CITY OF ALBUQUERQUE

March 24, 2017

RE: **Rain Tunnel Car Spa**
5401 Sevilla Ave
Grading and Drainage Plan
Engineer's Stamp Date 2/27/17 (File: F11D016)

PROJECT NO.	5401 SEVILLA AVE. NW
PROJECT NAME	COORS & SEVILLA ALBUQUERQUE, NM
PROJECT MANAGER	JONATHAN STERN
DRAWN BY	J.B.
JOB NO.	-
SHEET TITLE	SITE GRADING PLAN
DATE	03/27/17
SCALE	AS NOTED
Sheet	C1.0

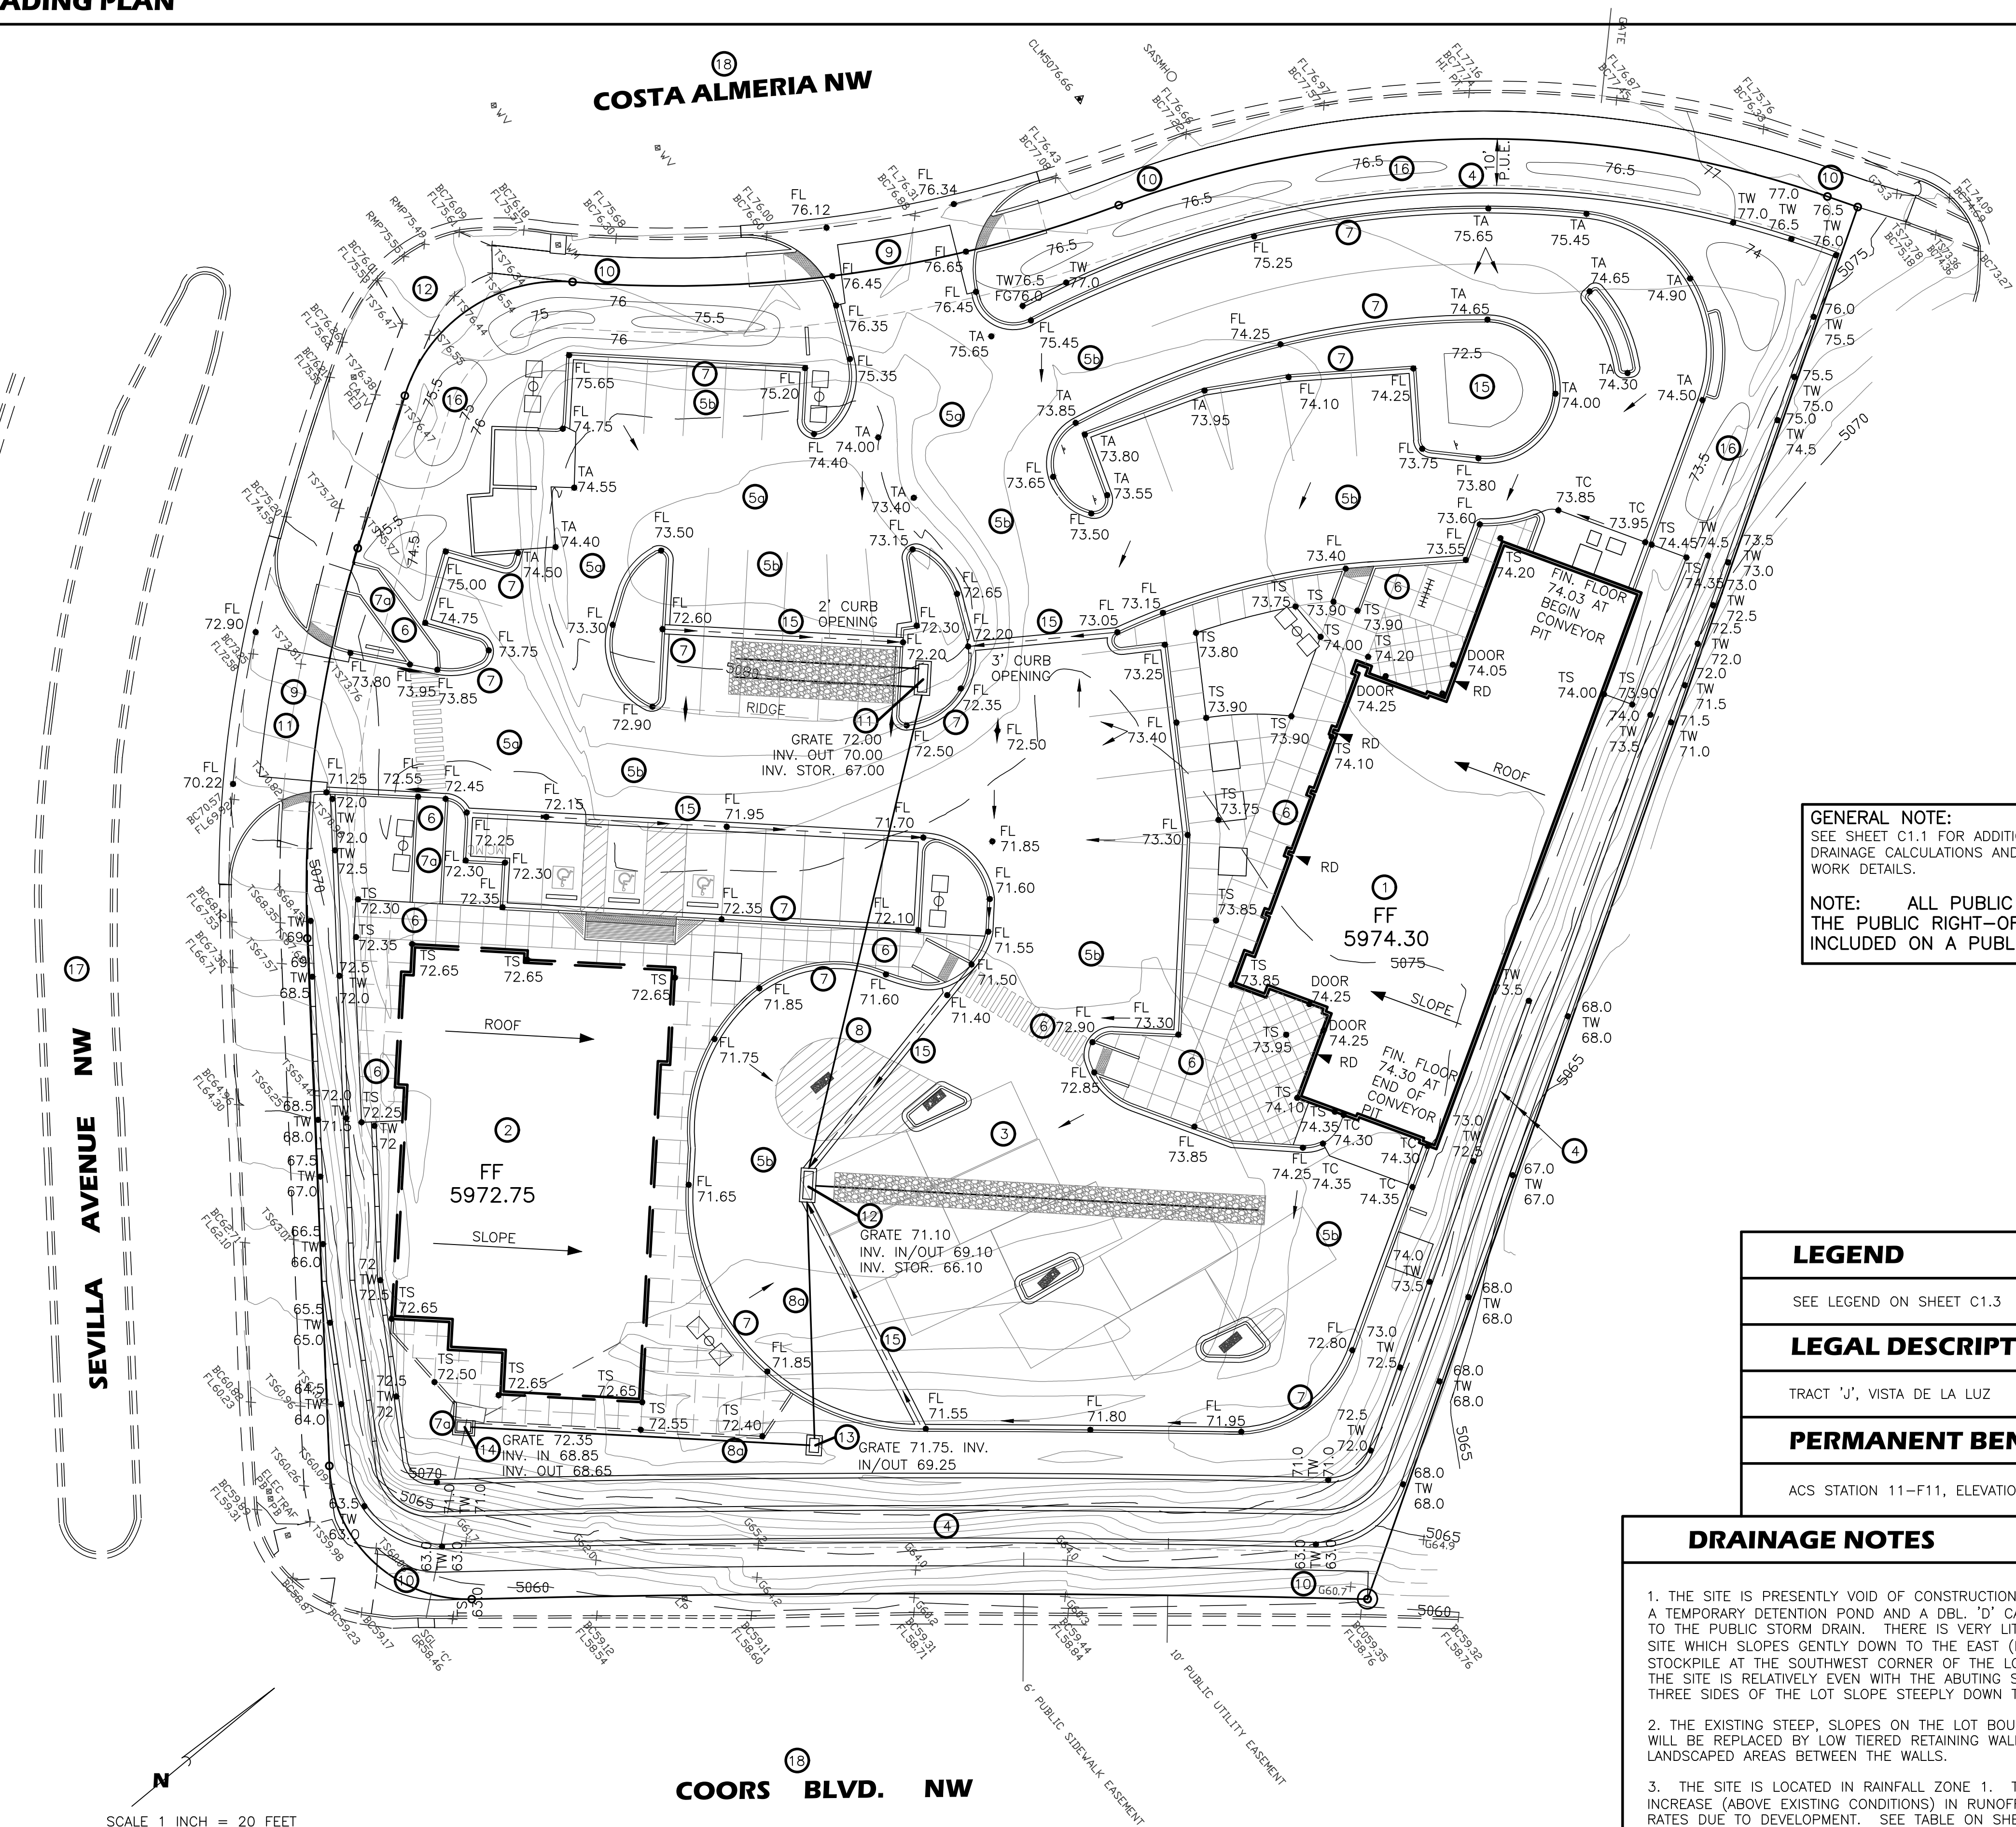
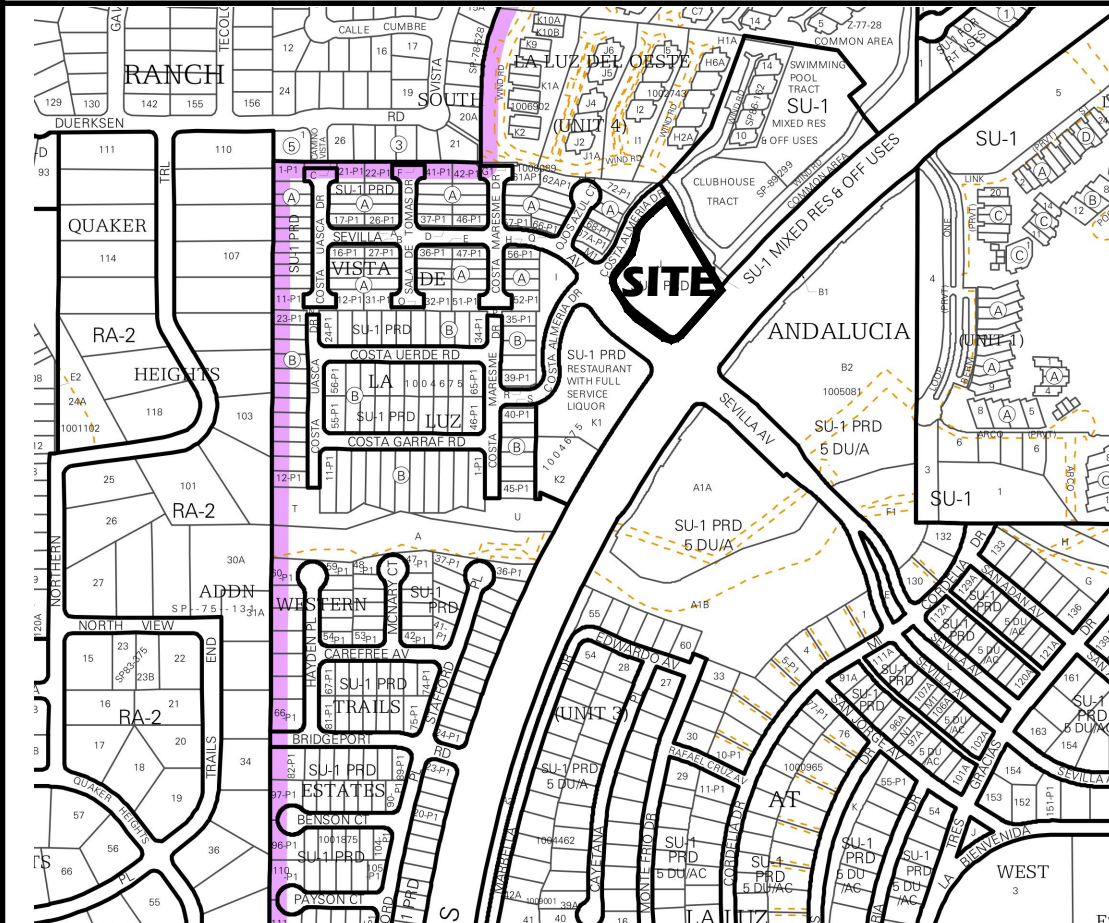
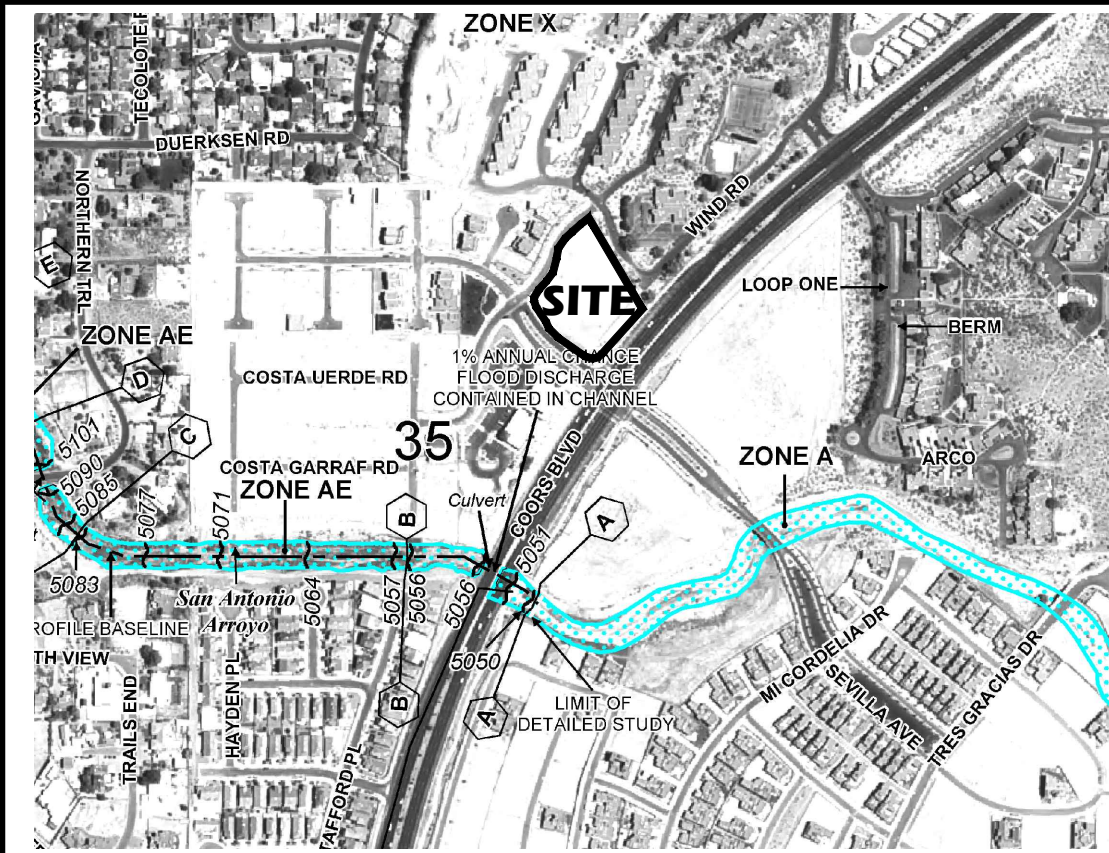
4. First flush volume should be based on $\text{AreaImpervious} \times (0.44 - 0.10) / 12$, not $\text{AreaImpervious} \times (0.42 - 0.10) / 12$.
5. Provide a waterblock, at least 0.87' high, at the entrance off Costa Almeria.

6. Confirm placement of keyed notes; several look out of place such as #11 at the entrance off Sevilla and #15 in the northern parking island.
7. This work requires an Erosion and Sediment Control Plan to be submitted to the storm water quality engineer (Curtis Cherne, PE, ccherne@cabq.gov).
